Per your request, a site visit was made to 6573 Old US 421 in Lillington, North Carolina to inspect and analyze the bottom of the footings.

Residential Single Family Project:  Y  N Commercial Project:  Y  N  
Code Enforcement Project No.: Permit No.: SFD2301-0105  
Project Name: CANNELL RESIDENCE Owner: DAVED E. CANNELL  
Project Address: 6573 OLD US 421, LILLINGTON, NC Suite No.:  
Date Inspected: 04/13/2023 Contractor Name: CLIFFORD STEVE THOMAS JR.  
Component Inspected: FOOTINGS FOR STEM WALL FOUNDATION

810A SD **MPB88Z - REINFORCED CONCRETE FOOTING**

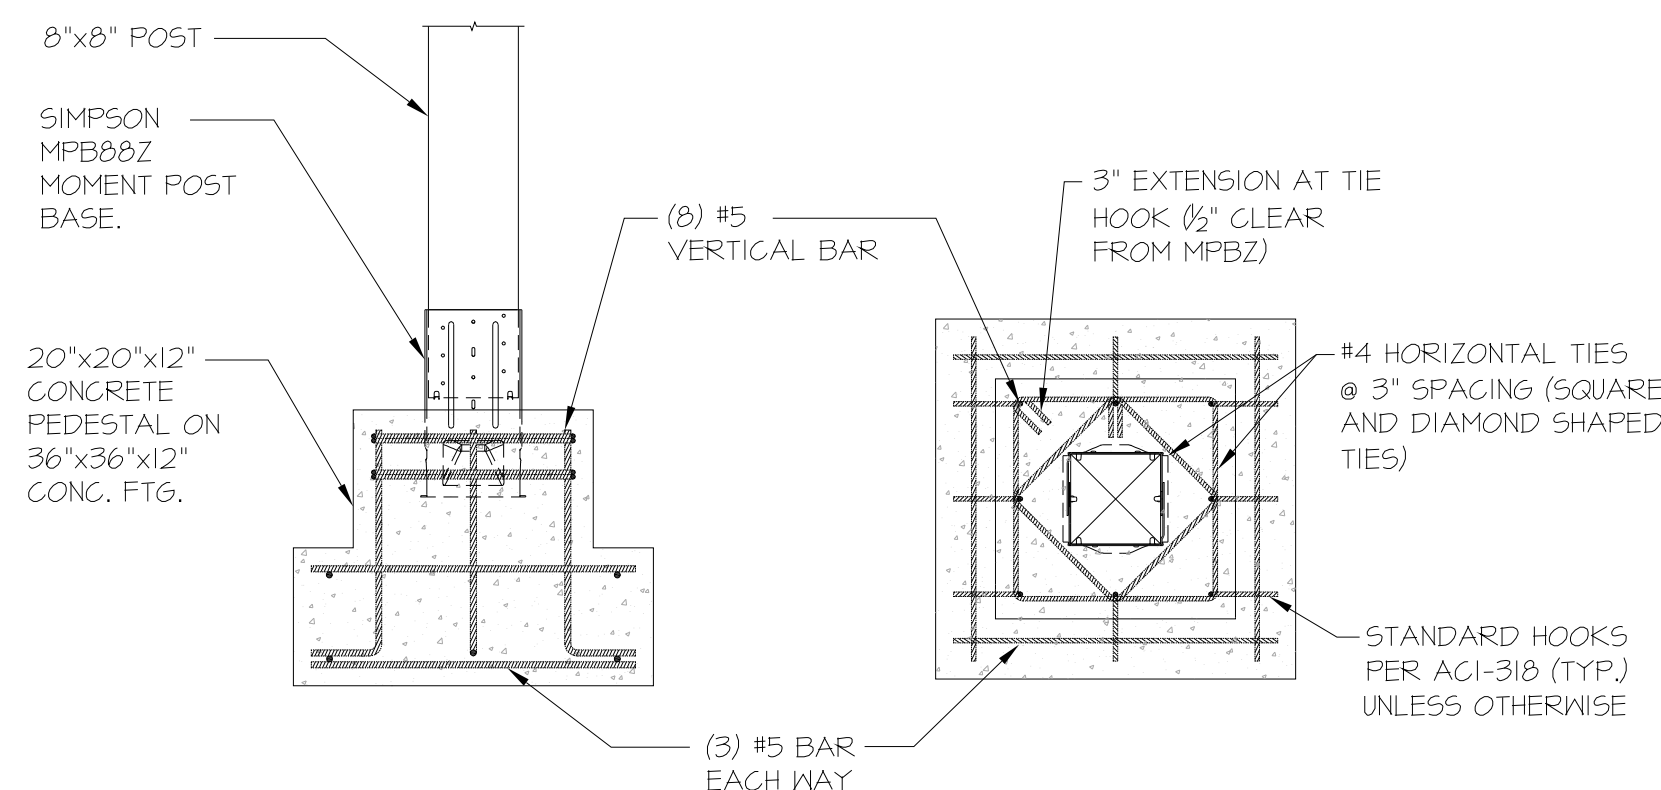
Third party inspection revealed one deviation. In lieu of embedding Simpson MBP88Z post bases in 20" x 20" concrete columns on 36" x 36" x 12" concrete footings reinforced with rebar per plan, the 8 x 8 treated posts supporting the vaulted portion of the rear porch are to be secured to the foundation with Simpson ABU88Z post bases and are to be braced with 4 x 4 treated knee braces. Knee braces are to be installed at a 45-degree angle and are to extend a minimum one-third of the post height down from the top of the post. Knee braces are to be fastened to the posts with a 1/2" diameter hot-dipped galvanized through bolt with a nut and washers and are to be fastened to the headers with a 1/2" diameter hot-dipped galvanized lag screw with a washer. Besides the deviation noted above, the remainder of the footings were excavated per the approved plan with all concrete depths and step downs set correctly. The footings are in conformance with Chapter 4 of the 2018 North Carolina Residential Code and are suitable for concrete placement.
